File Ref: DN21/0031

Development Referral No. DN21/0031

**Proposal: Environmental Impact State for the Sutherland Hospital Operating Theatre
Upgrade (SSD-11099584) CR21-518201**

Property: 126 Kareena Road, Caringbah

LANDSCAPE PLANTING AND SHADE CONSIDERATIONS

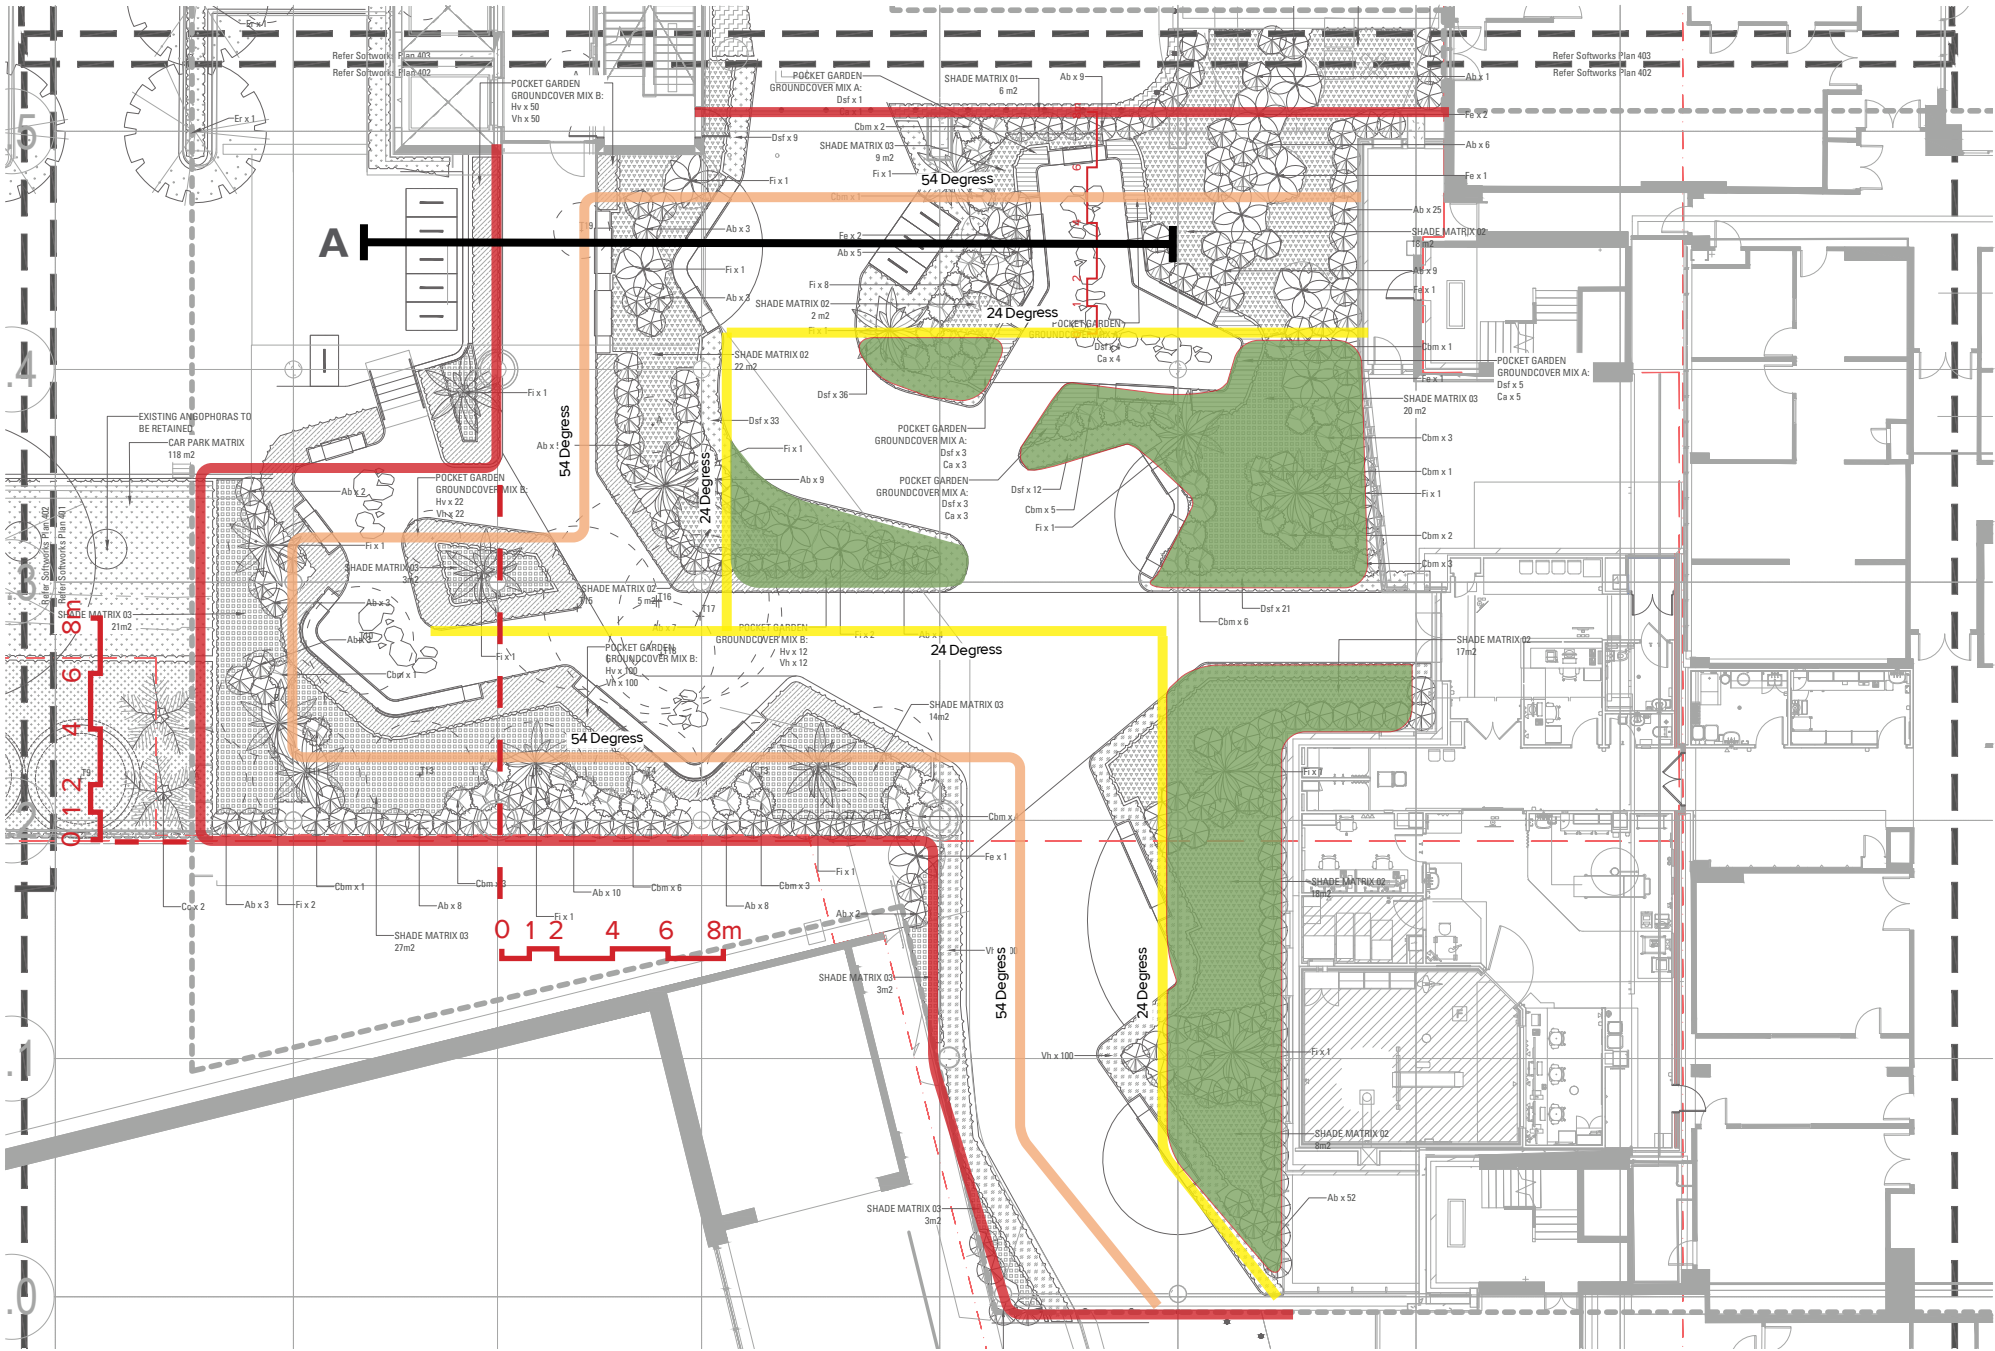
- iv) The landscape proposal is sited beneath the upstairs theatre rooms and is unlikely to gain any sunlight, with northern sun blocked by the lift core. A communal landscape area would better service the community if re-located to the roof.

- v) Plant species below the cantilever will need to be shade and wind tolerant as this area will become a wind tunnel. Irrigation will be essential due to its enclosed nature.

Fig 72: Diagram highlighting building edges

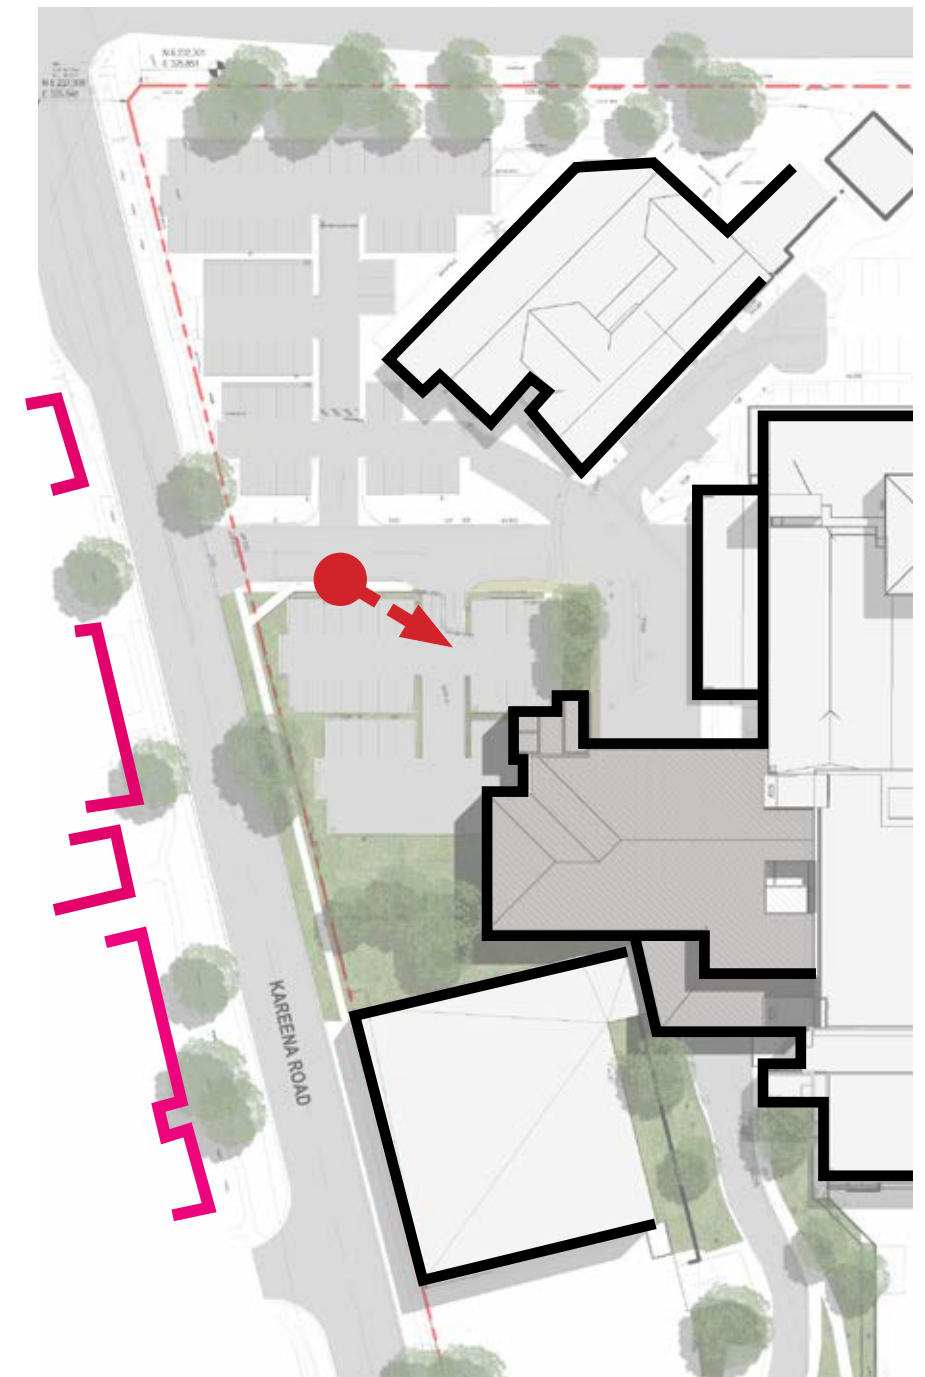
- i) The external expression and chosen materials for the proposed addition relate comfortably with the existing buildings. The only aspect which may confuse the public is the prominence placed on the new entry along the northern elevation as it seems to be more for staff access. As the public's main entry will remain unchanged, this new entry may confuse the public.
